Department for Transport

Date: 29 October 2021

Application by Highways England (“the Applicant”) for an Order granting Development Consent to authorise the widening of an approximately 20.6km stretch of the existing A1 between Morpeth to Ellingham, with approximately 14.5km of online widening and approximately 6.1km of new offline highway (“the Proposed Development”).

REQUEST FOR COMMENTS FROM THE APPLICANT AND NORTHUMBERLAND WATER (“NW”), NORTHERN POWERGRID (“NPG”), NORTHUMBERLAND COUNTY COUNCIL (“NCC”), MR HAWES AND MR DAVIDSON.

Figure 1 – DCO Application proposed PMA Route

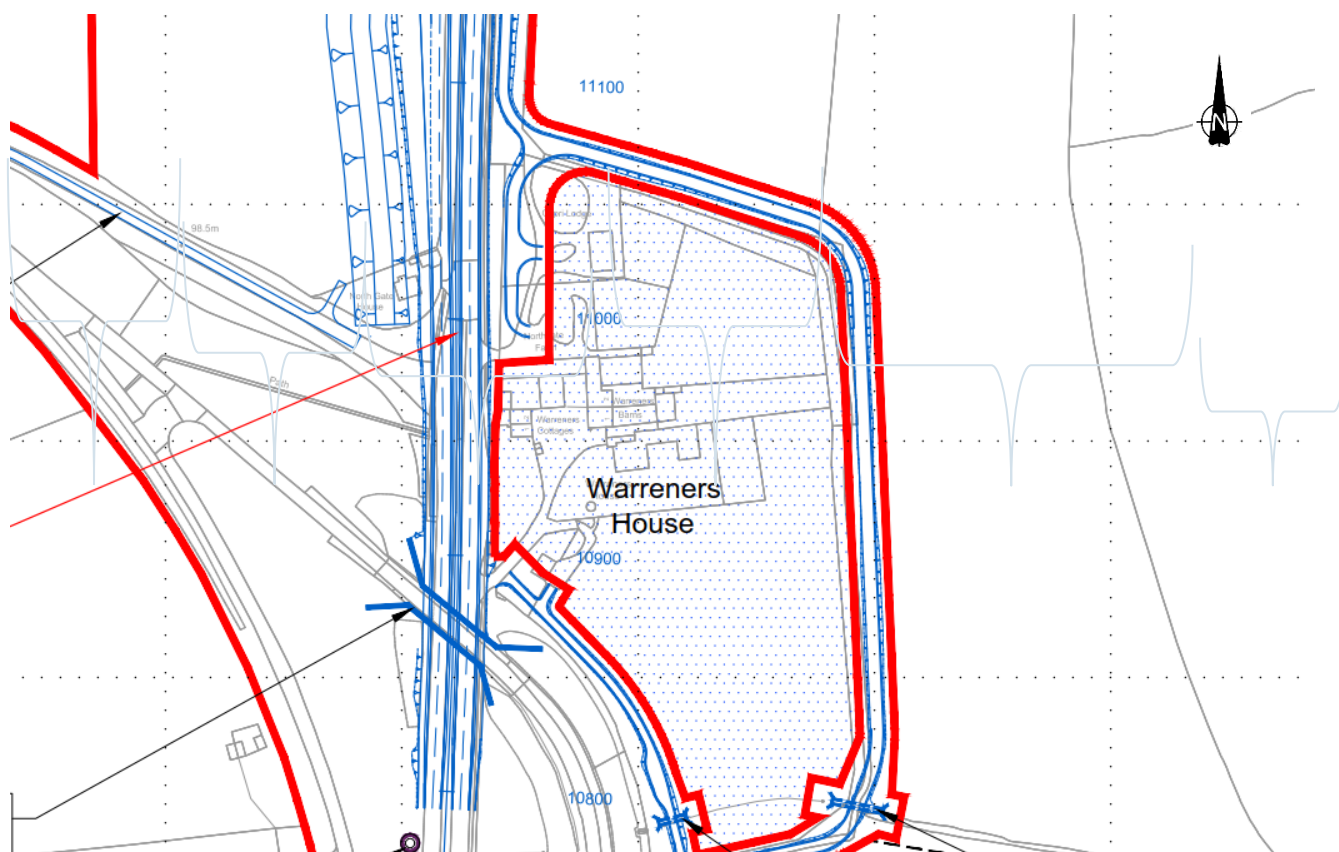
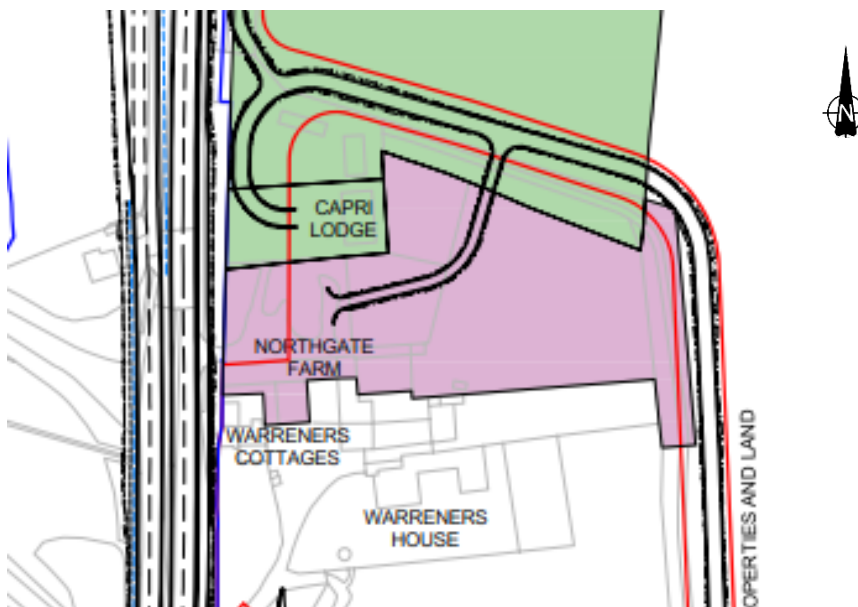
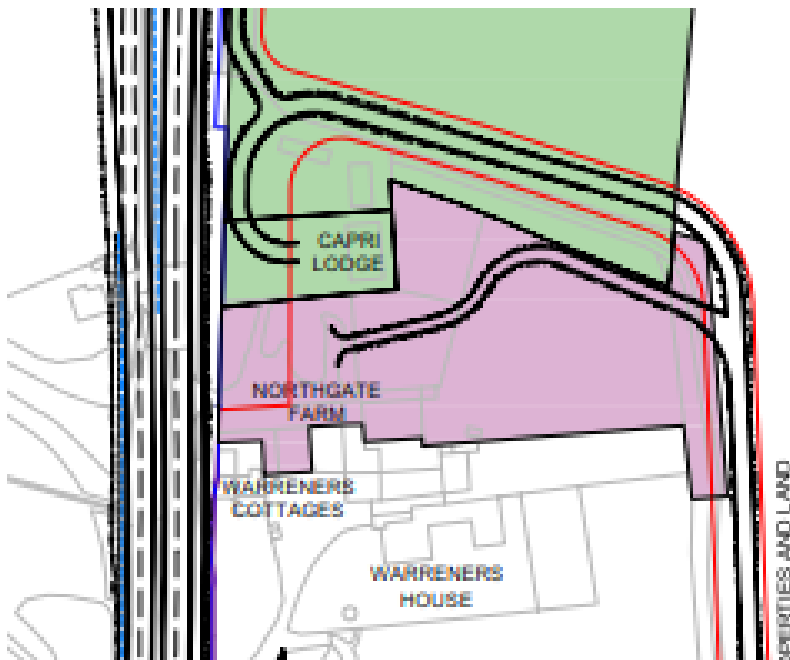
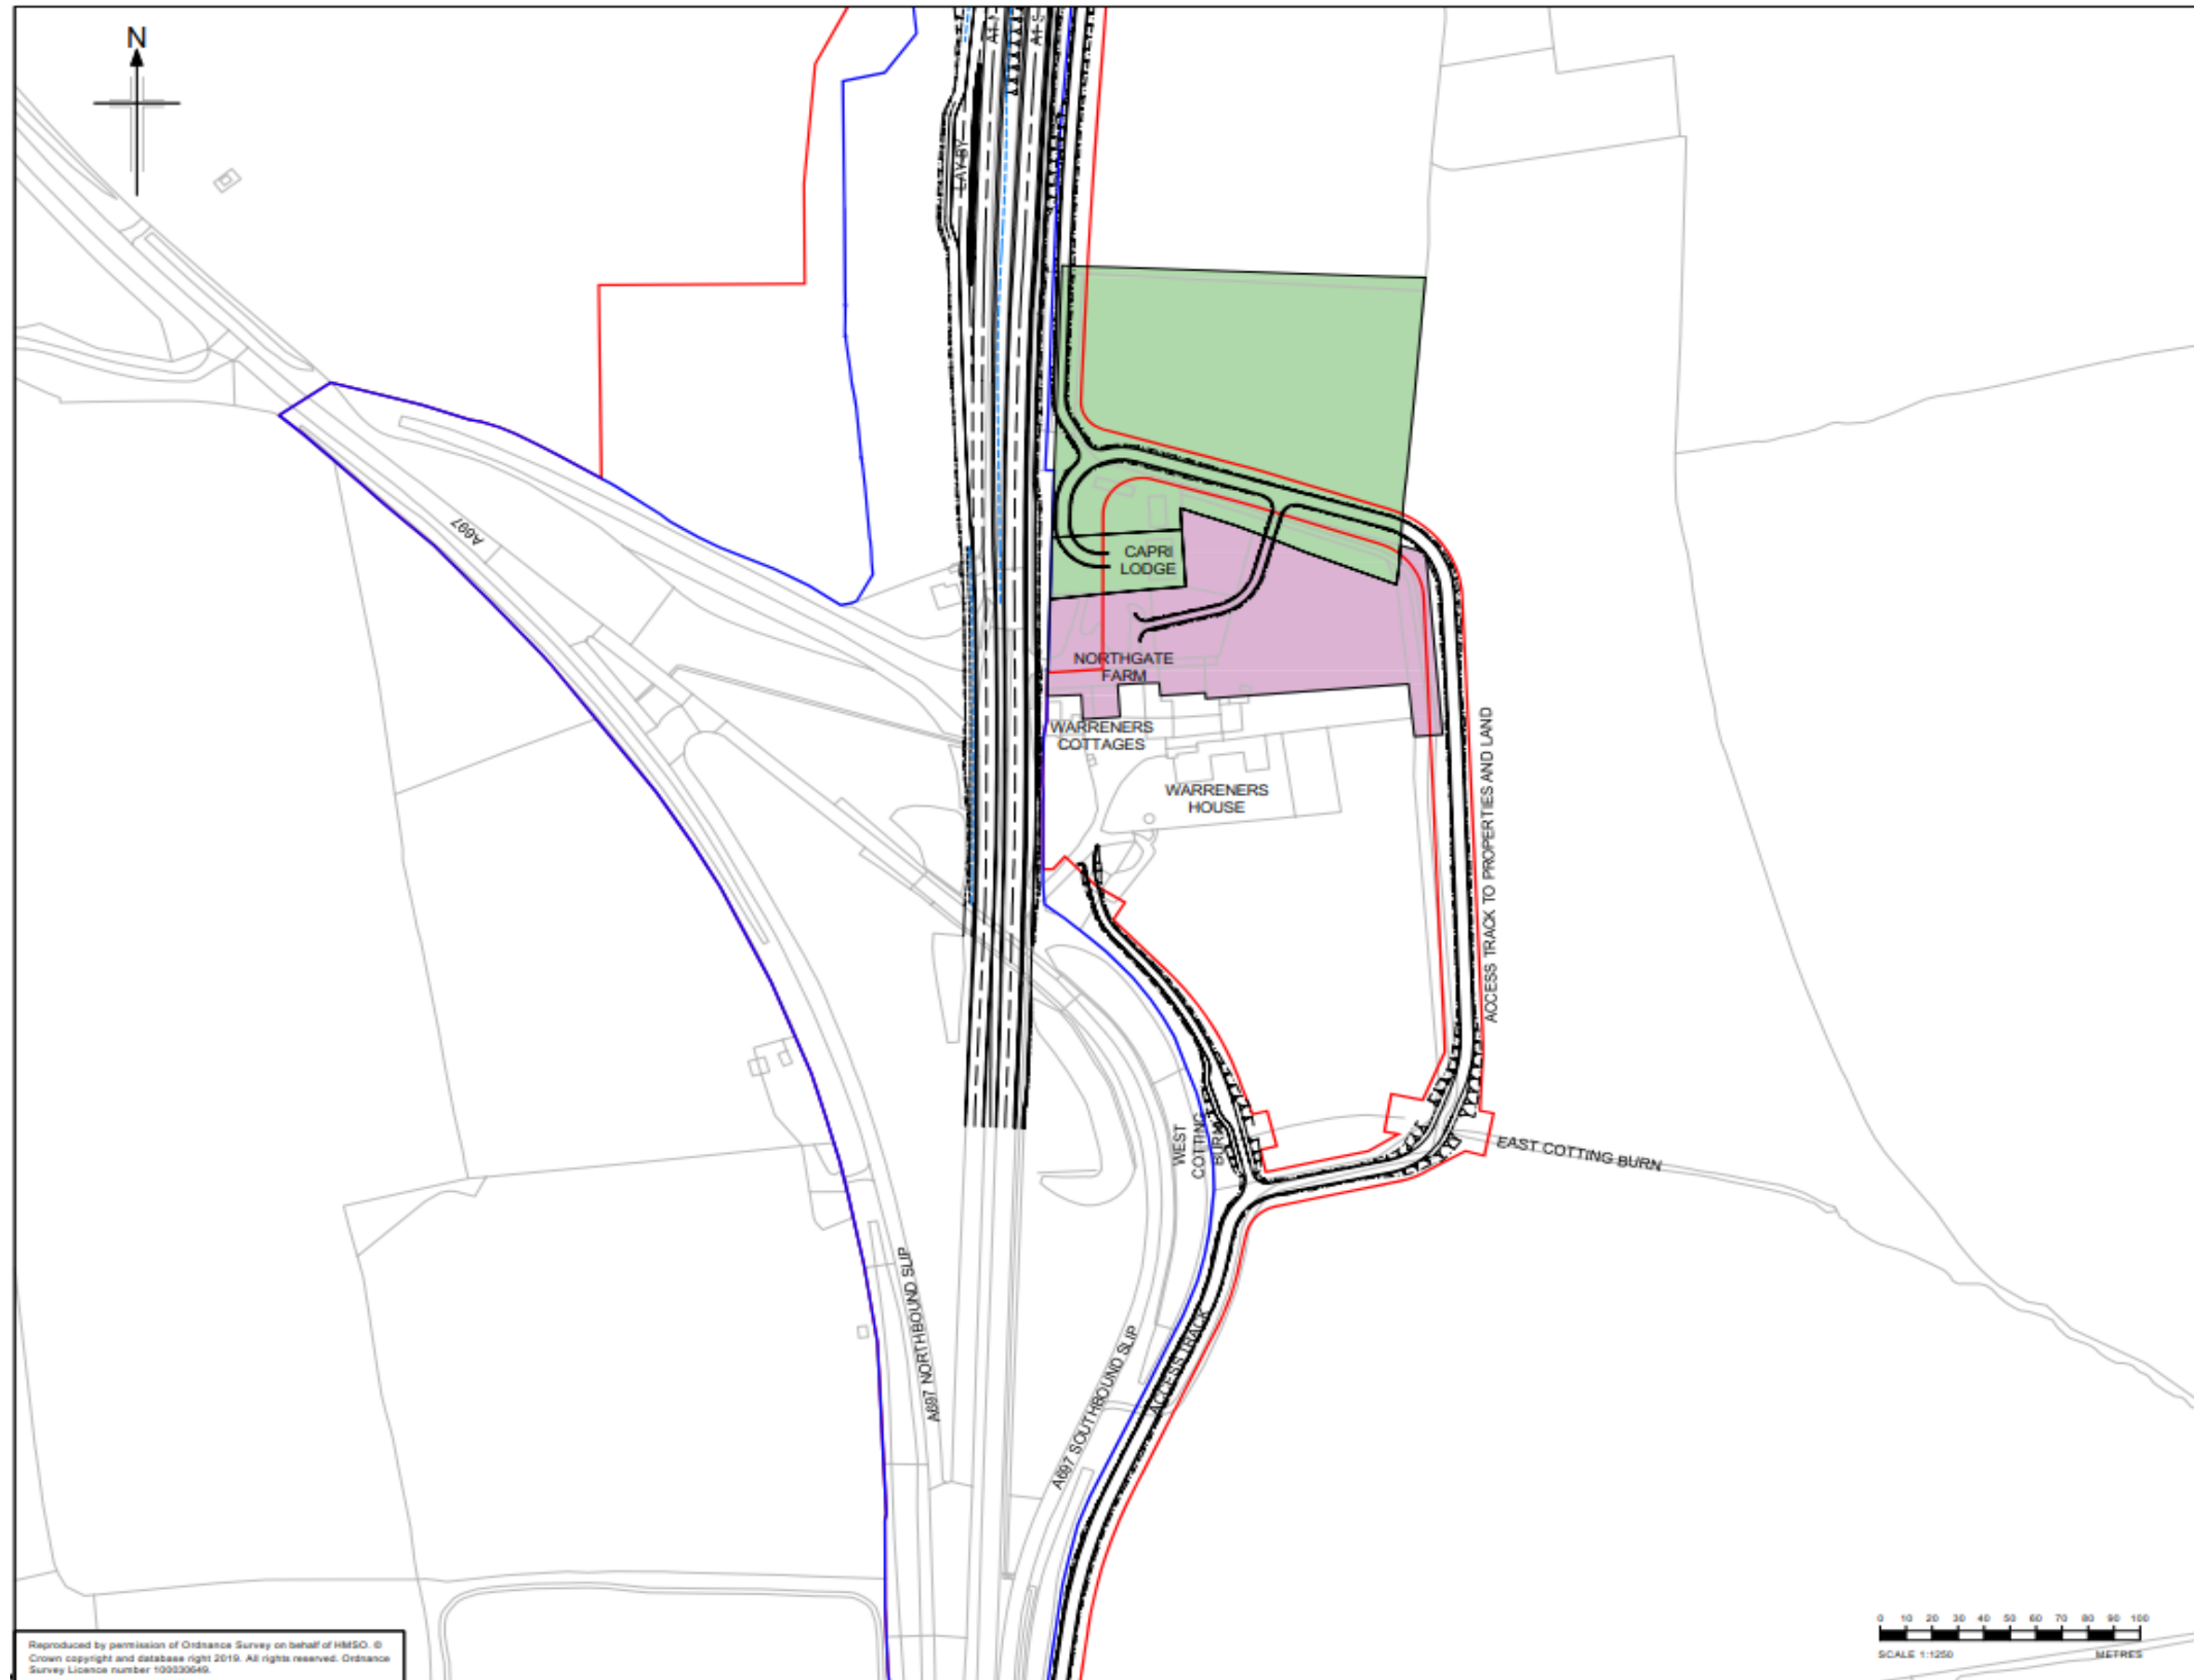
The Secretary of State notes the Applicant's position on the replacement access that would be provided to Northgate Farm and Capri Lodge [\[REP10-37\]](#).

Please could the **Applicant** and **relevant interested parties (including Mr Hawes on behalf of residents of Northgate Farm and Mr Davidson)** comment on the status of any further discussions about the location of the access track, and in particular on whether any agreement has been reached as to its location.

In order to provide the three alternatives in the DCO that were considered during the examination, the Secretary of State is minded to include a revised description of Work No. 5b in Schedule 1 to the proposed development consent order as follows:

Work No. 5b - a new access track being one of—

Work No. 5b(a) 832m in length to the north of the West View turning circle commencing at grid reference 418259E; 5888134N and terminating at grid reference 418254E; 588647N; or

Work No. 5b(b) 677m in length to the north of the West View turning circle commencing at grid reference 418259E; 5888134N and terminating at grid reference 418342E; 588723N; or

Work No. 5b(c) 552m in length to the north of the West View turning circle commencing at grid reference 418259E; 5888134N and terminating at grid reference 418391E; 588764N.

Please could the **Applicant**:

- (a) confirm whether the specifications of the grid references and track lengths are accurately reflected in the three options that were under consideration during the examination;
- (b) confirm that each of the options would be deliverable under the development consent order; and
- (c) provide revised versions of the relevant sheets of the Works Plans and Land Plans to show any changes that would be required?
